From: Bloomer, David <David.Bloomer@lancashire.gov.uk>
Sent: 15 August 2018 12:32
To: Adam Birkett
Cc: LHS Customer Service; planning
Subject: app3/2018/0576 Fairclough House Loudbridge

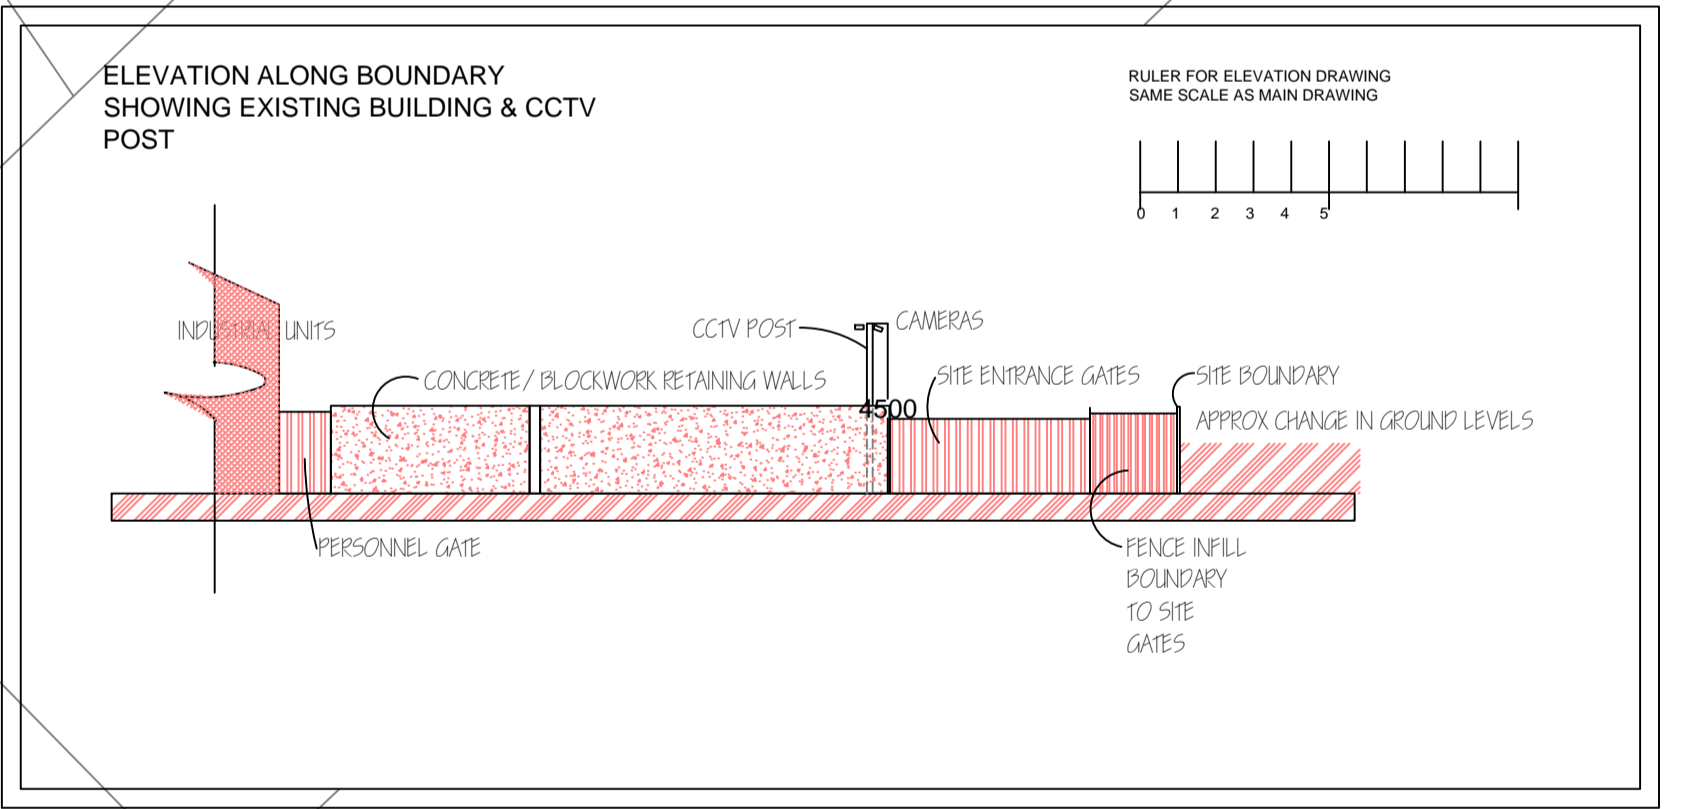
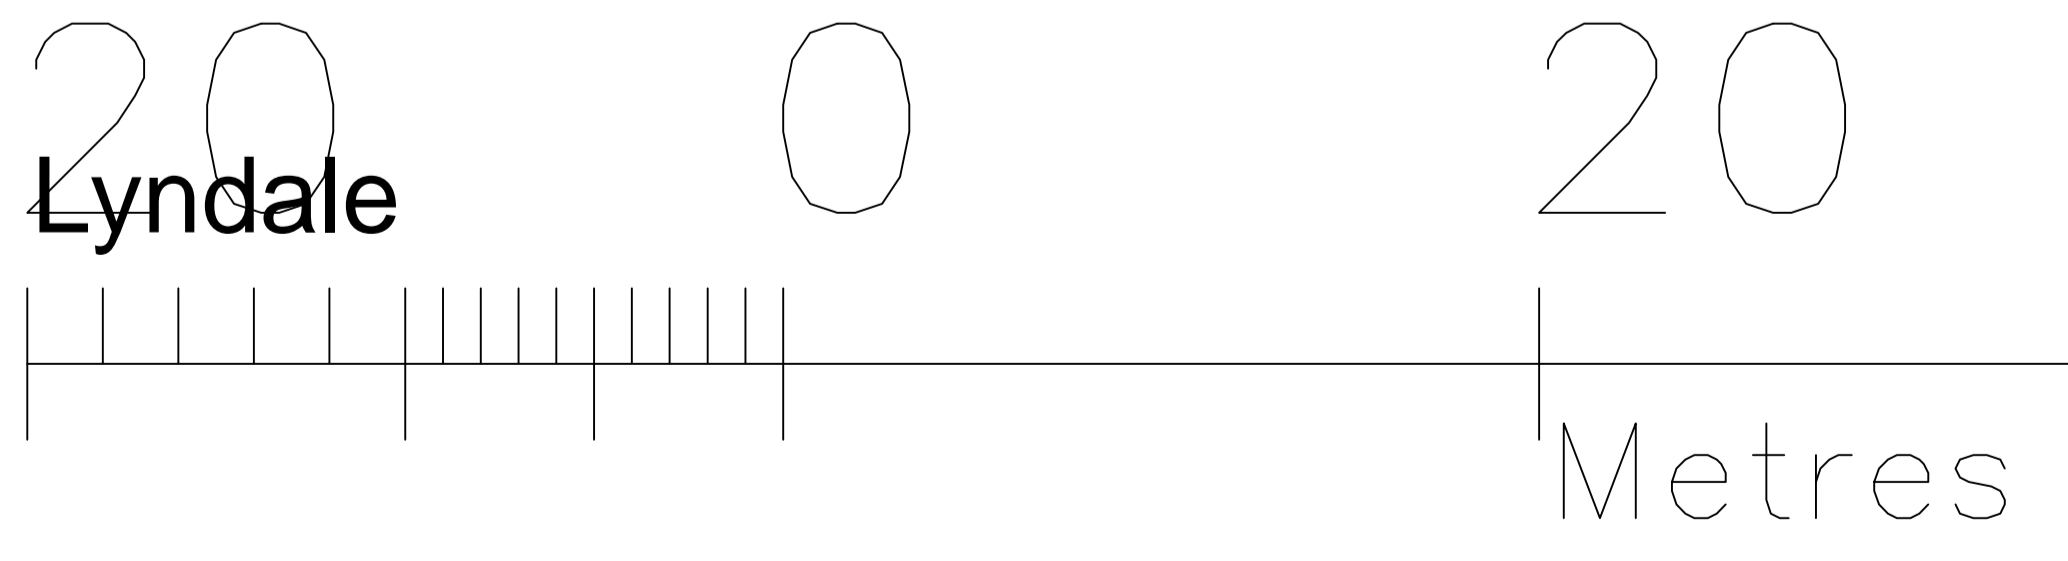
The proposal as you have stated in your previous correspondence is a tidying up of outstanding matters but as you are aware I have concerns regarding the lawful use of the site and in particular the size of vehicles entering and exiting the site at the present time. And on this basis I have the dilemma of knowing that the entry and exit from the site may involve the larger vehicles entering or leaving the site in a reverse gear which is contrary to good road safety practice. What I do not want to portray is the highway authority's acceptance that the access is suitable for all uses. In correspondence you mention that the lawful use at present is as a builders yard/joiners workshop and on this basis the access, albeit over engineered, raises no highway concerns and consequently no objection. If the lawful use was proven to include the use of the site as an HGV depot i.e. Lancashire Crushers, then the right turn in / out of the site will need to be demonstrated as being suitable for all their vehicles by means of a swept path analysis and since this information has not been provided I would have to raise an objection
